Our Case Number: ABP-309770-21

**An
Bord
Pleanála**

Date: 21 April 2022

Re: Proposed development of up to 15 wind turbines with a tip height of up to 175 metres and laying of approximately 26km of underground electricity cabling to facilitate the connection to the national grid, and all associated site development works
Townlands of Camagh, Carlanstown, Coole, Clonrobert, Clonsura, Doon, Monktown, Mullagh, Newcastle and other townlands, Co. Westmeath

DRAINAGE DRAWINGS

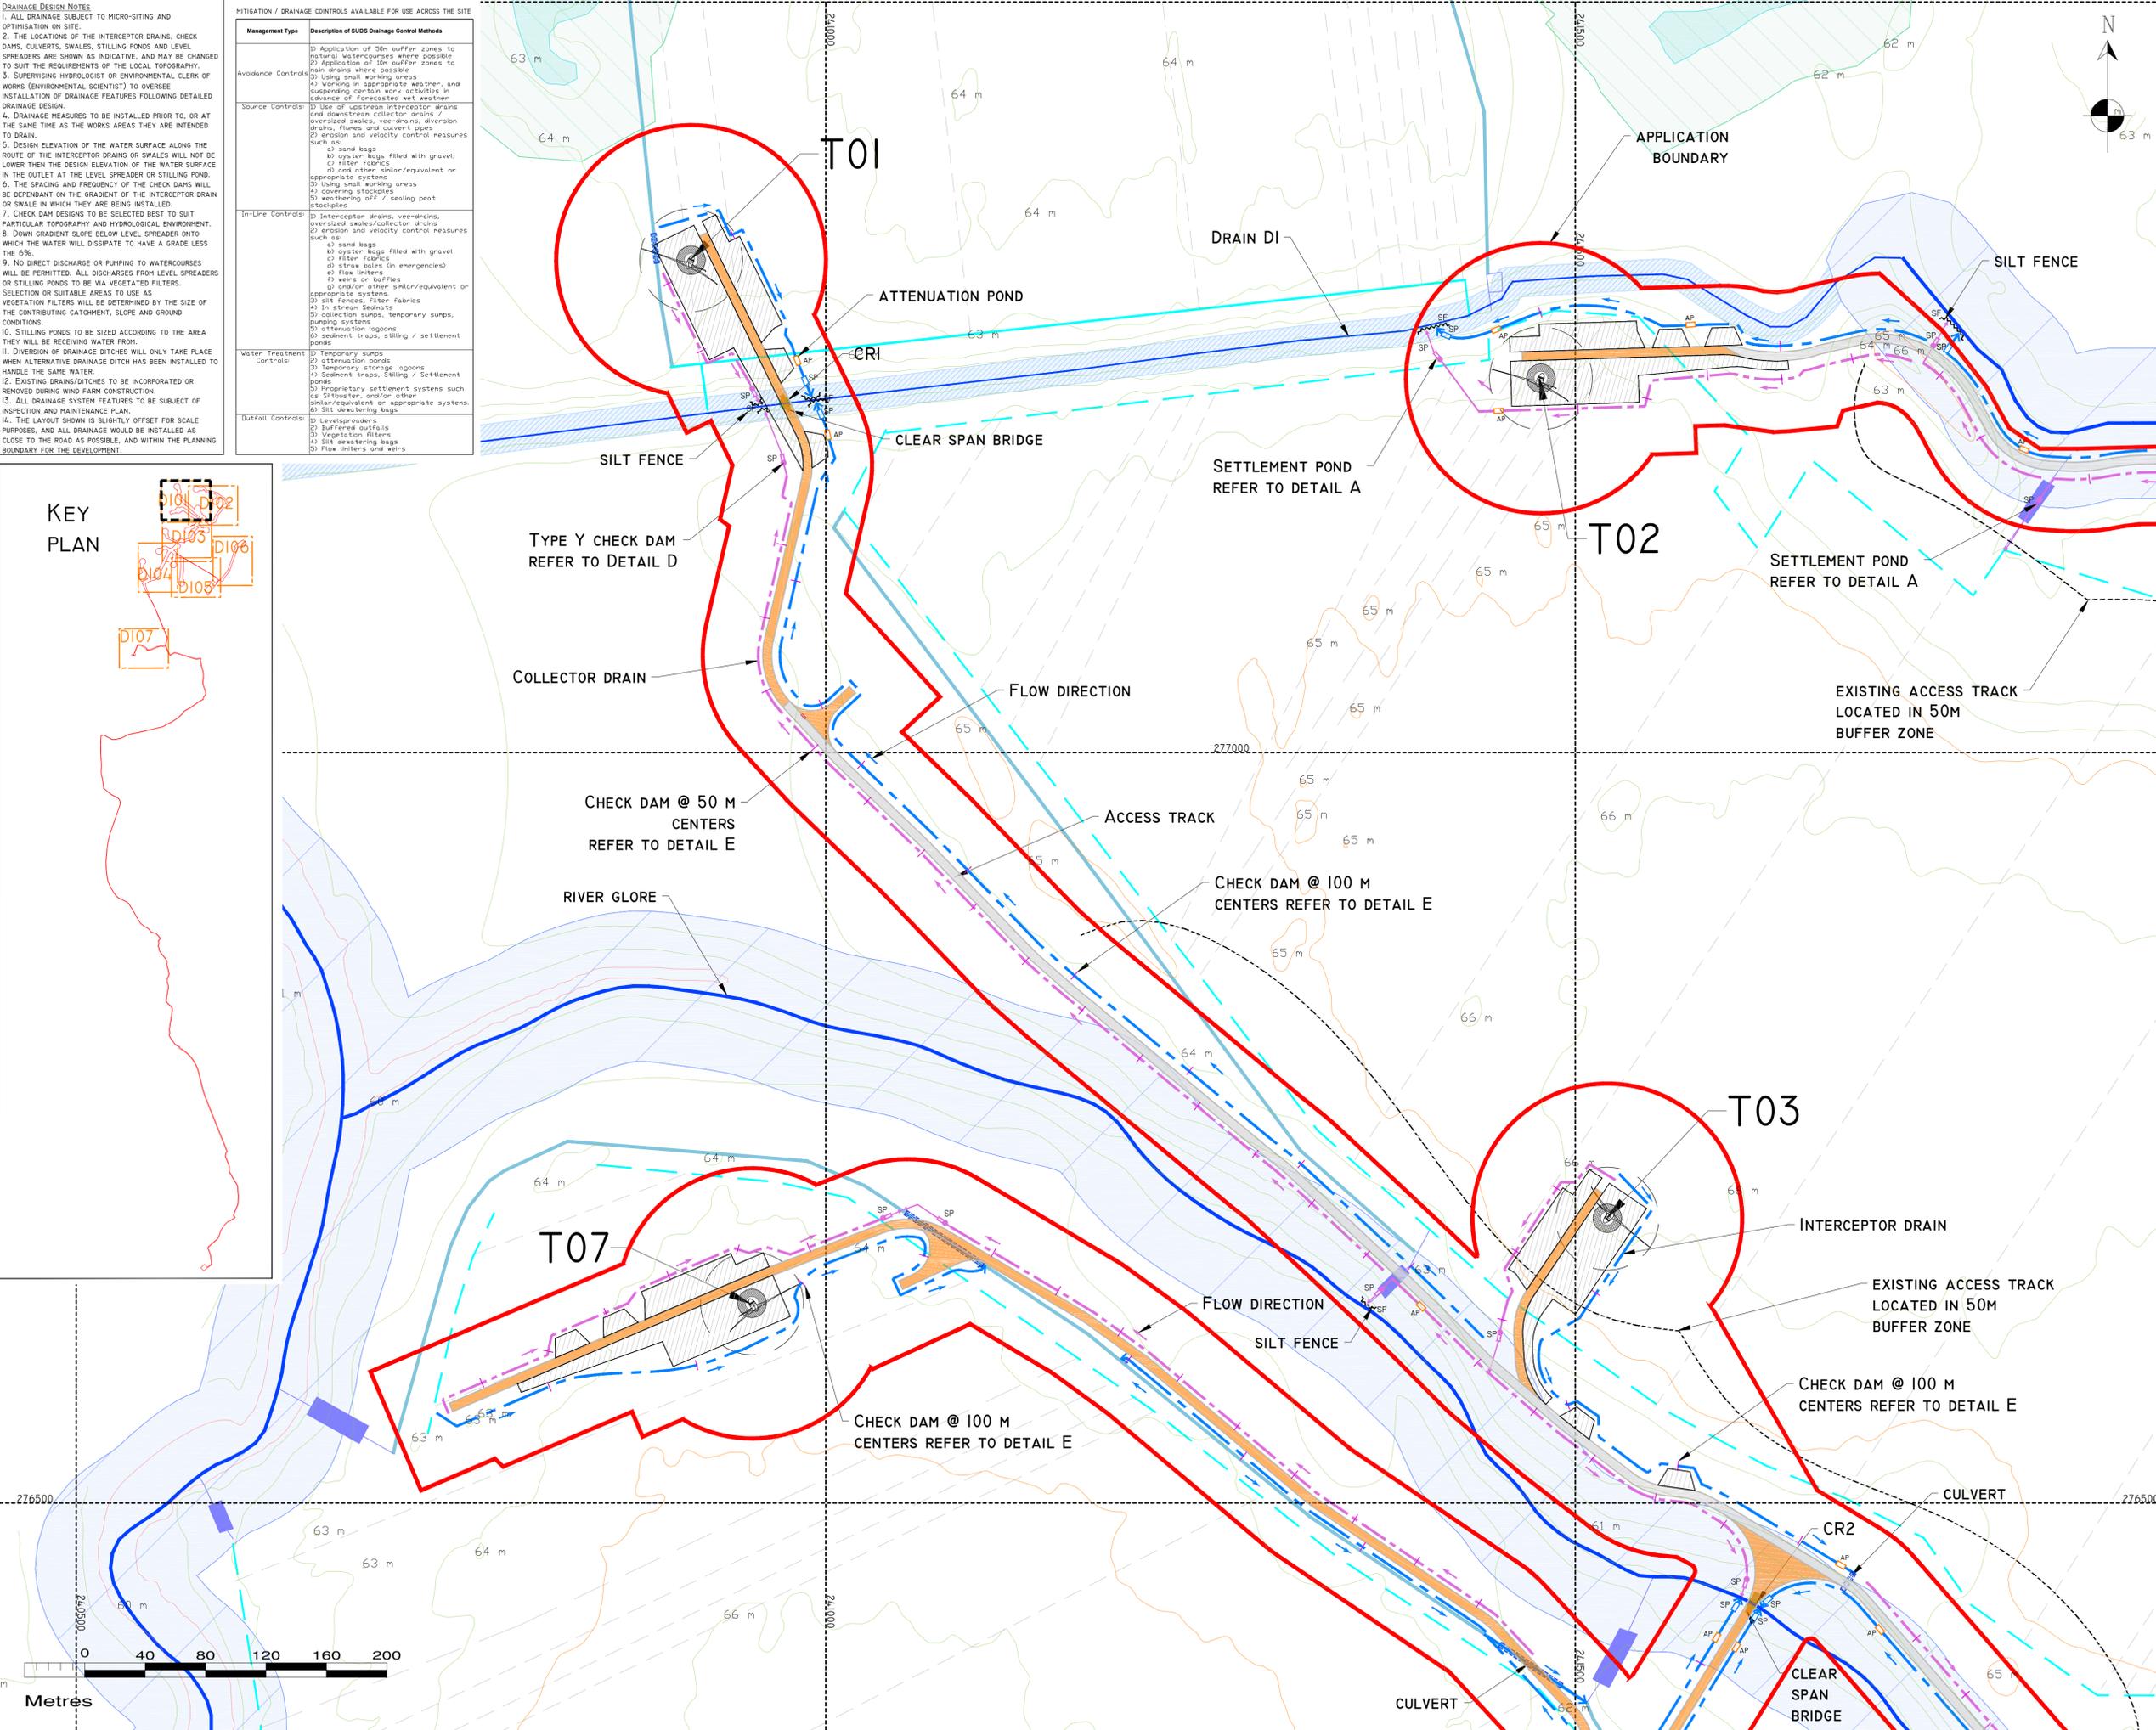
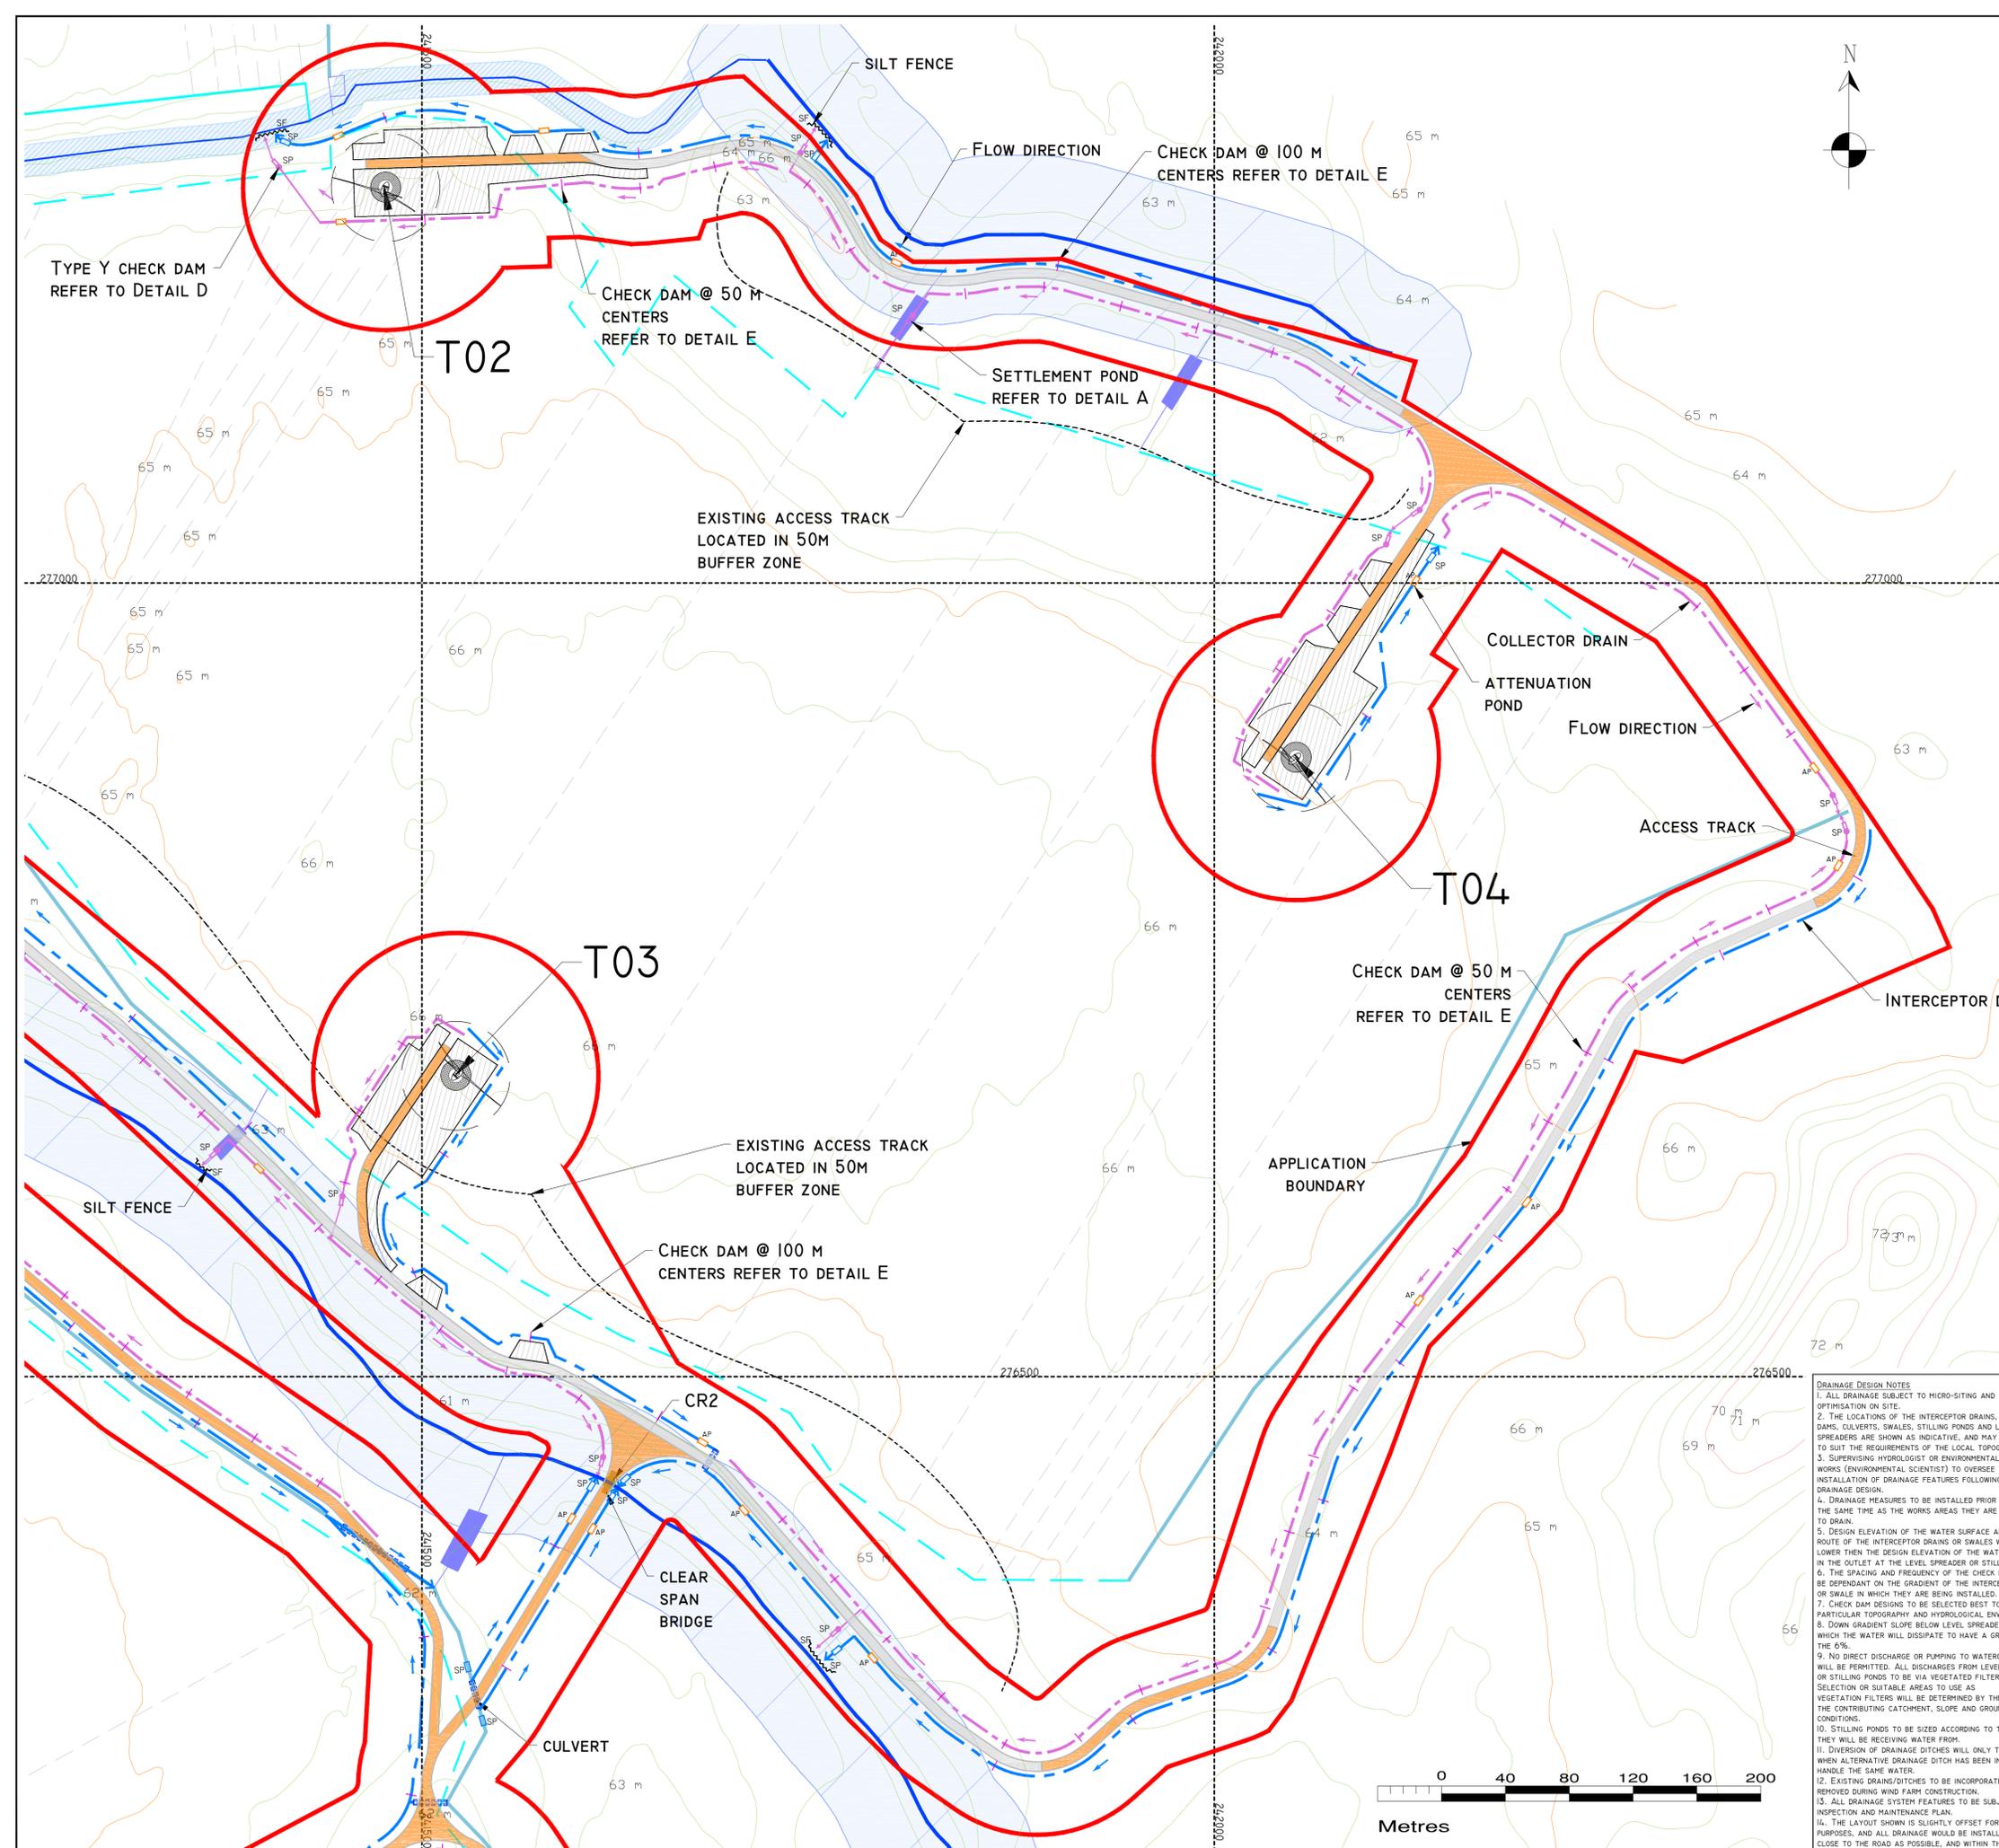
- 4.3. The EIAR is stated to set out the coordination between the peat harvesting activities should they continue and the proposed development in terms of the drainage system. The detailed drawings provided in appendix 9 – 3 of the proposed drainage system are noted. You are requested to demonstrate sufficient control over the existing drainage associated with the peat harvesting activities and to clarify that the proposed drainage plan can be effectively implemented, regardless of whether or not peat harvesting is taking place and the associated drainage system being maintained.

- 4.5. You are requested to clarify the layout and management arrangements for the operational phase drainage structure.
